Application Reference Number:	2026/0222
--------------------------------------	-----------

Proposal Description:	Erection of single storey extension to the front of existing shop to be used as additional retail floor space
------------------------------	---

Location:	Yogi Convenience Store, 75 Huddersfield Road, Barnsley, S75 1AA
------------------	---

Ref.	Dwg. No.	Rev.
2025/83	02	A

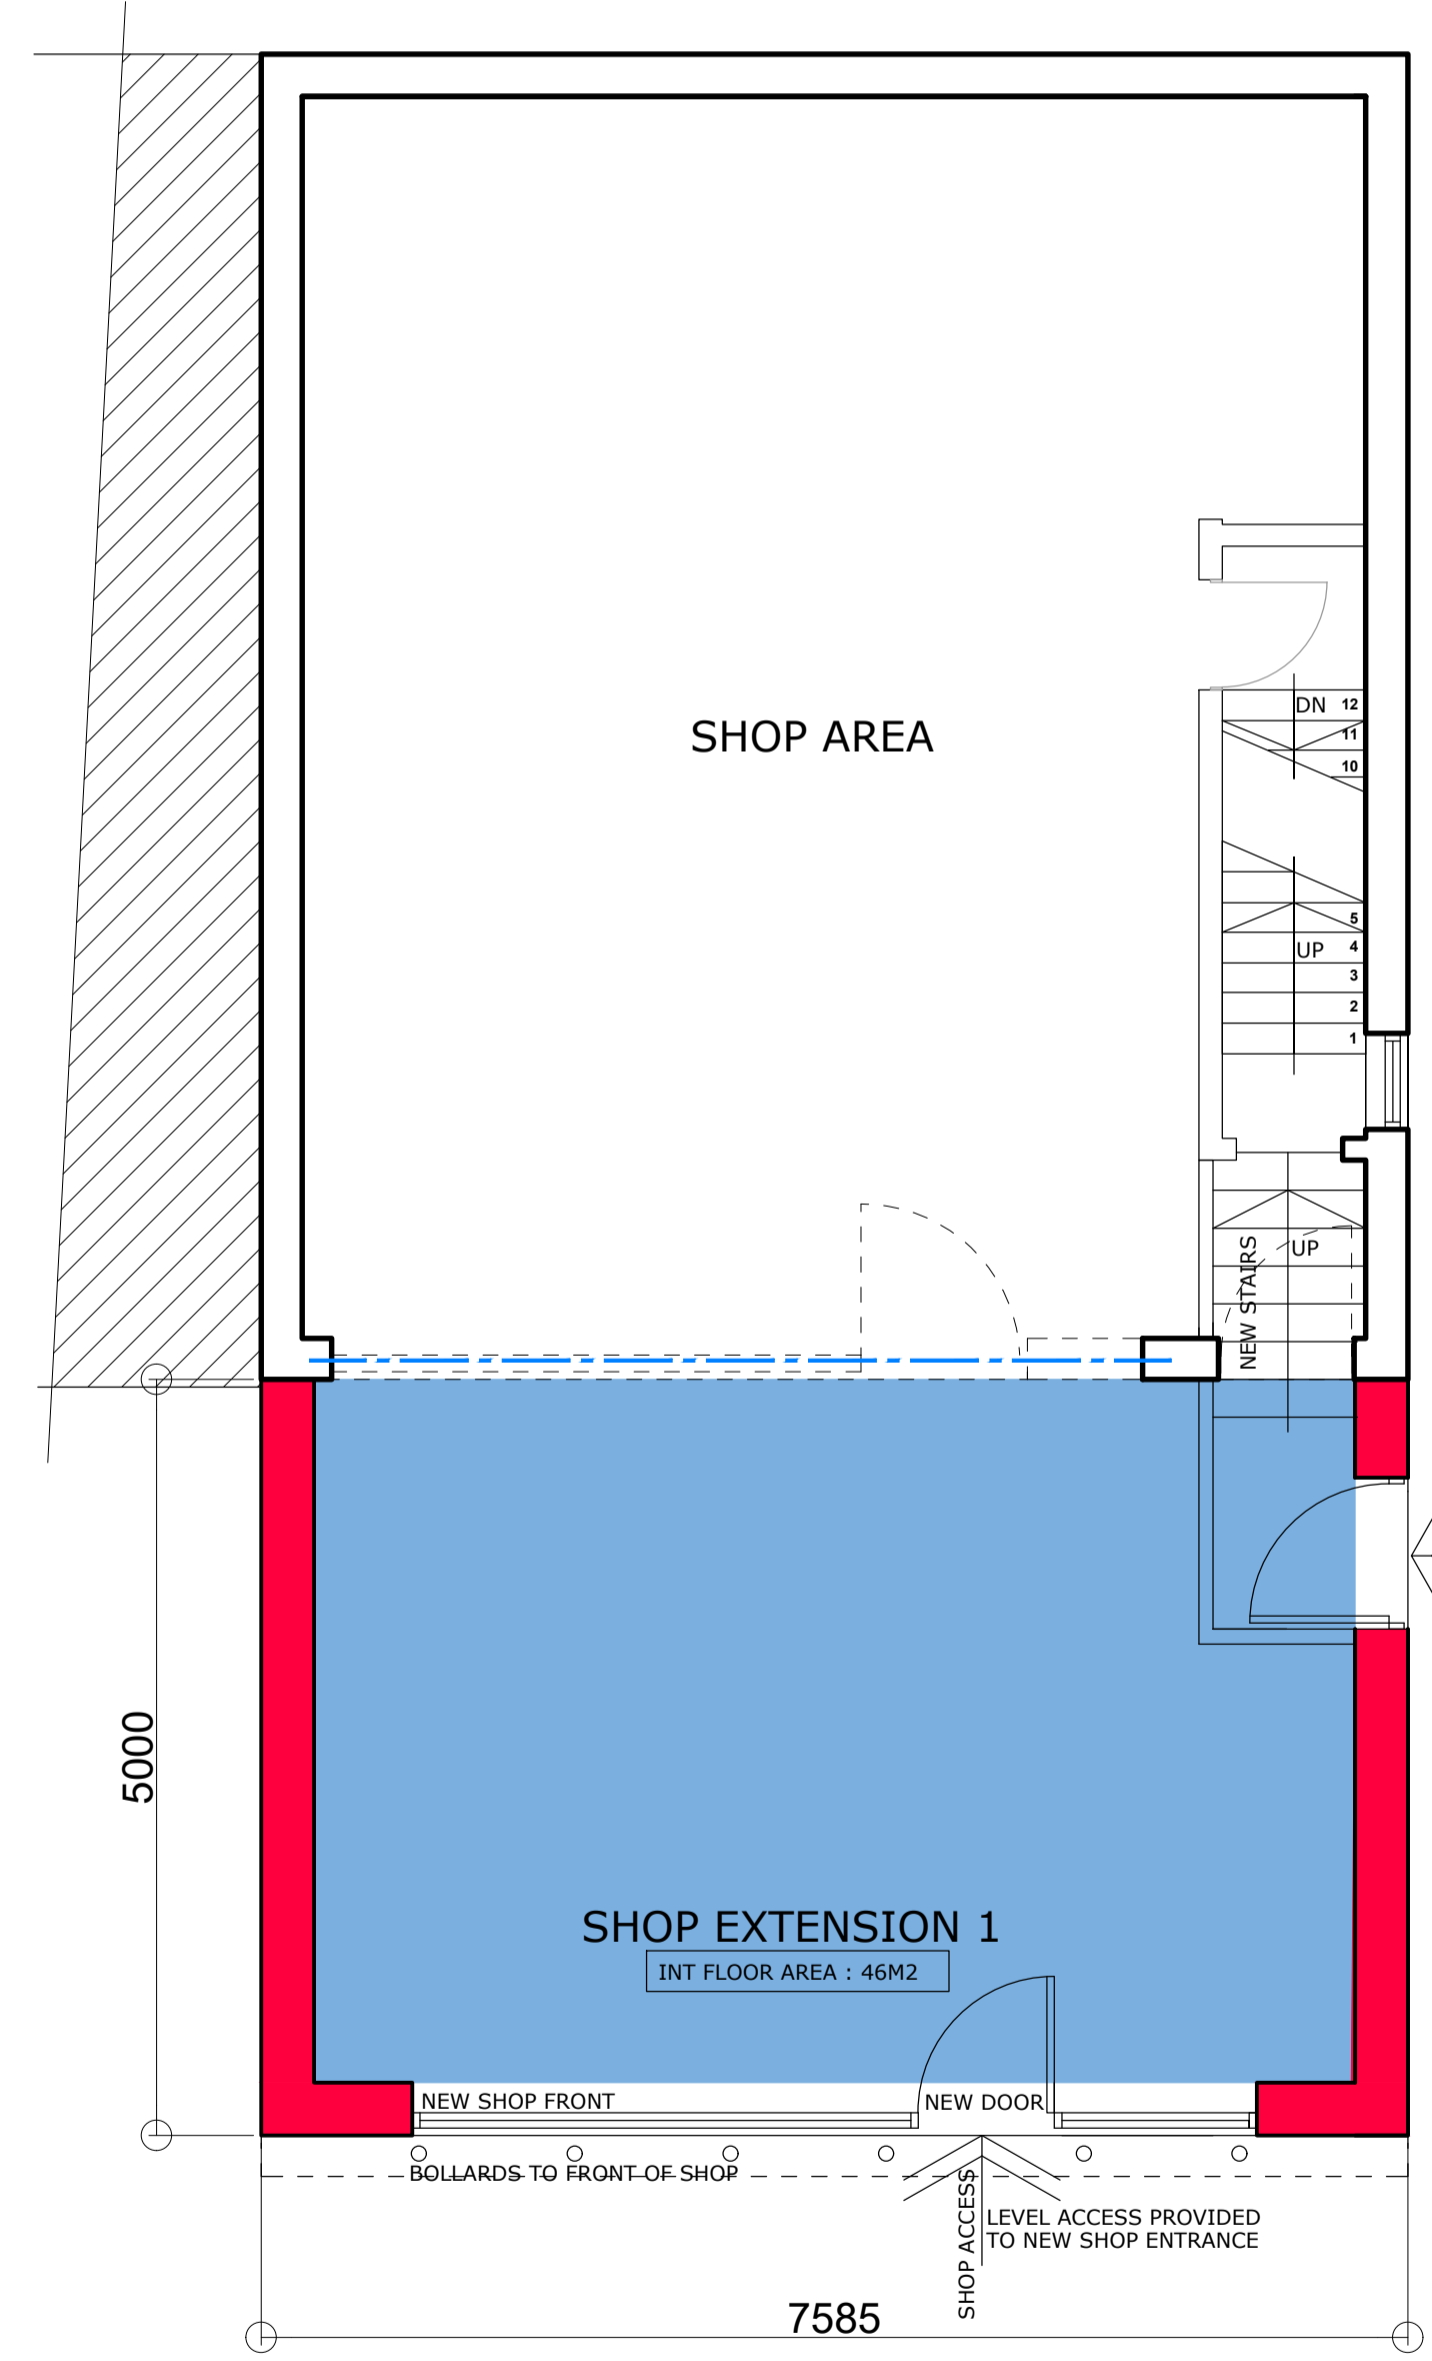
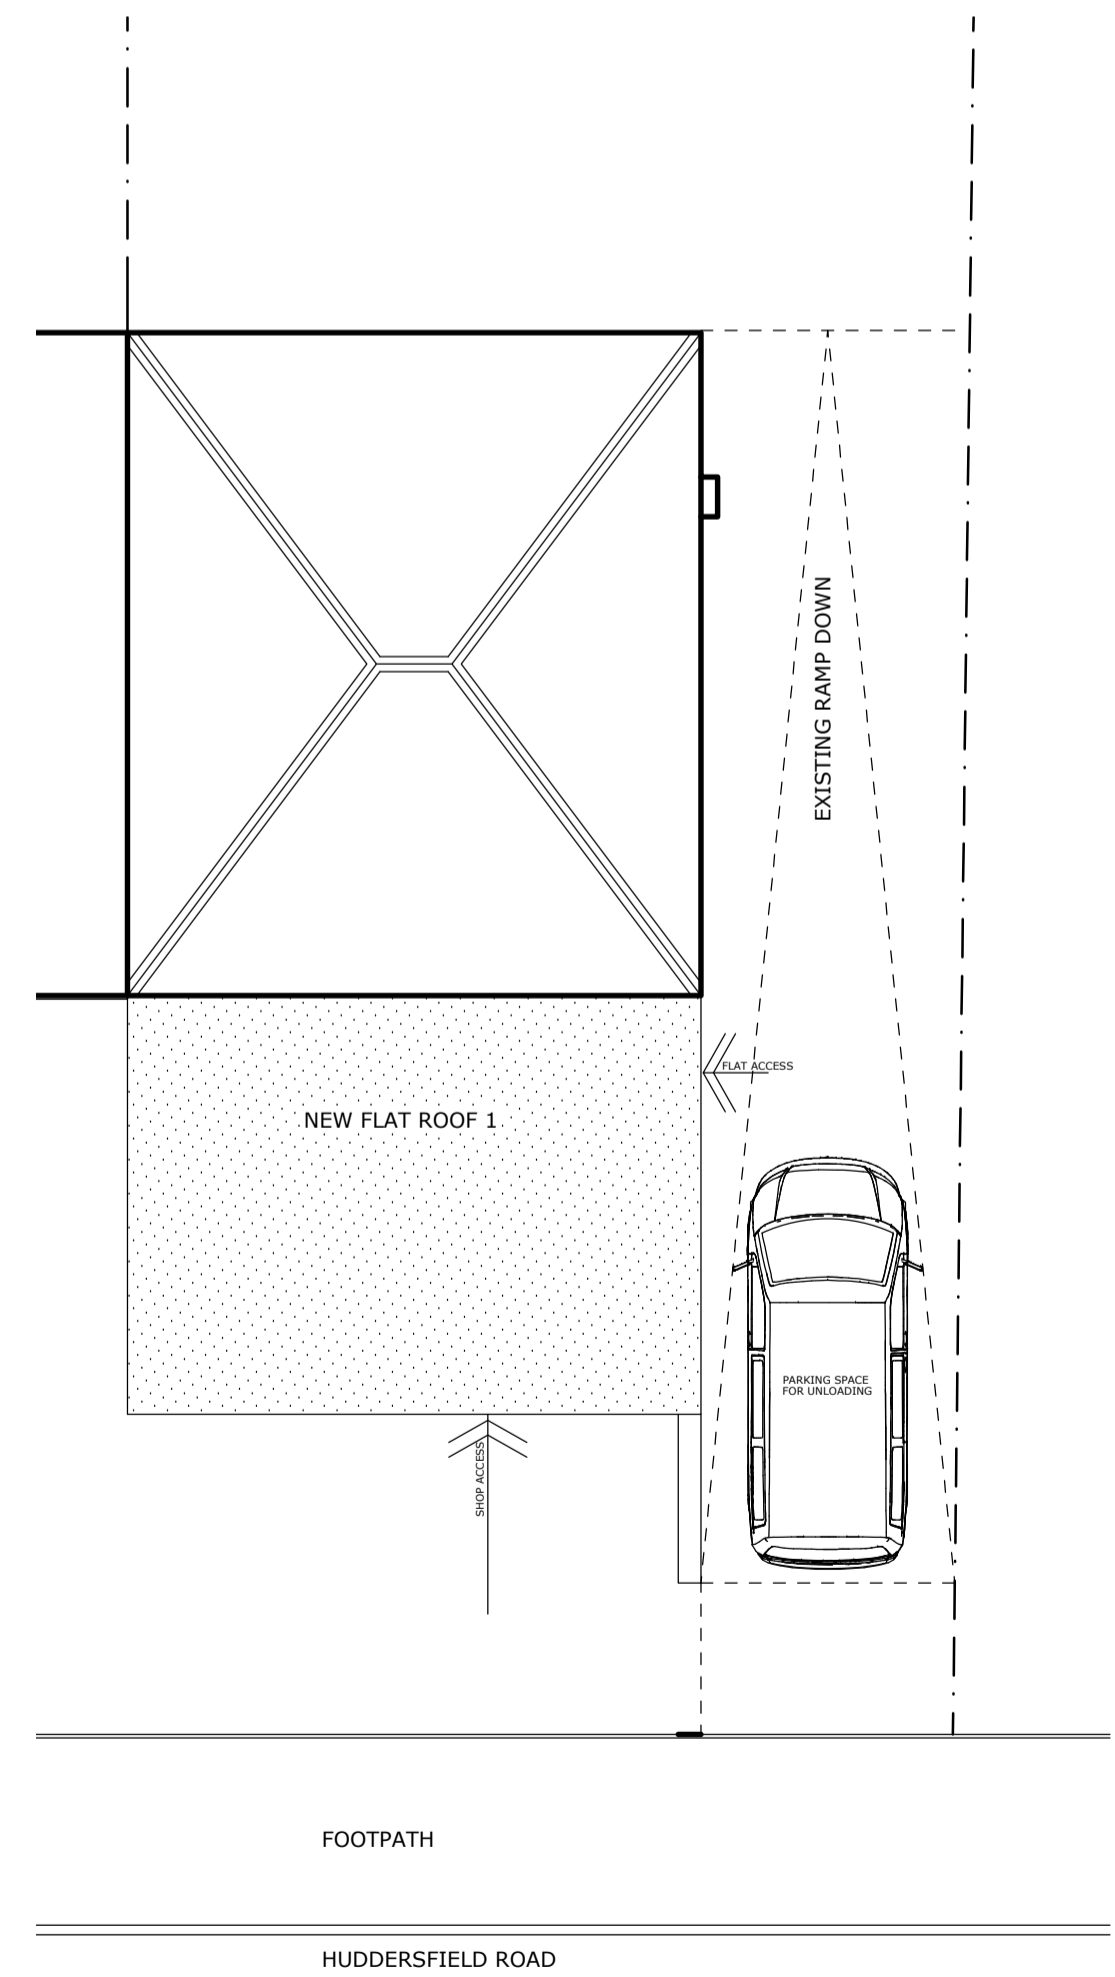
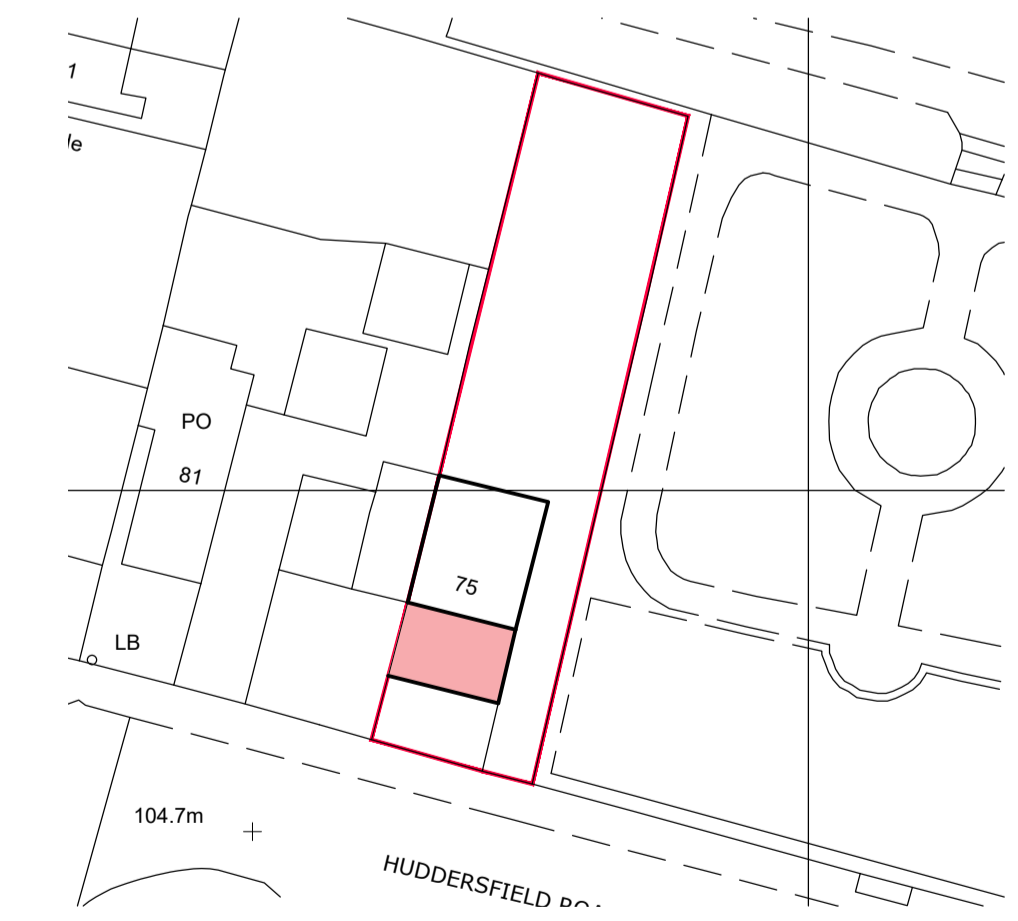
The applicant is seeking approval for a single storey front extension to the existing retail unit. The extension will project 7 metres from the existing front elevation of the shop. The extension has a width of 7.6 metres. The extension will feature a flat roof with a total height of 3.15 metres when measured from the front elevation. The materials will be matching brickwork to the existing building. During the course of the application the forwards projection was reduced to 5 metres.

It must be noted that the proposal was amended with a reduction in forwards projection and the application re-consulted on. One further comment was received in relation to the re-consultation stating the projection should match the adjacent extensions and questioning bin storage.

It must be noted that application 2024/0965 was approved for the same extension but with a 4 metre forwards projection instead of the proposed 5 metre forwards projection. Therefore, this presents a fallback position that could be implemented.

The proposed extension would simply move the shop front of the existing building forward 5 metres and only 1 metre from the previous approval and reflect the design of the existing shopfront. The elevations of the extension would be matching brickwork to the existing building. This weighs significantly in favour of the proposal.

The front projection shall match the existing front extensions on adjacent properties and shall not extend beyond this point.
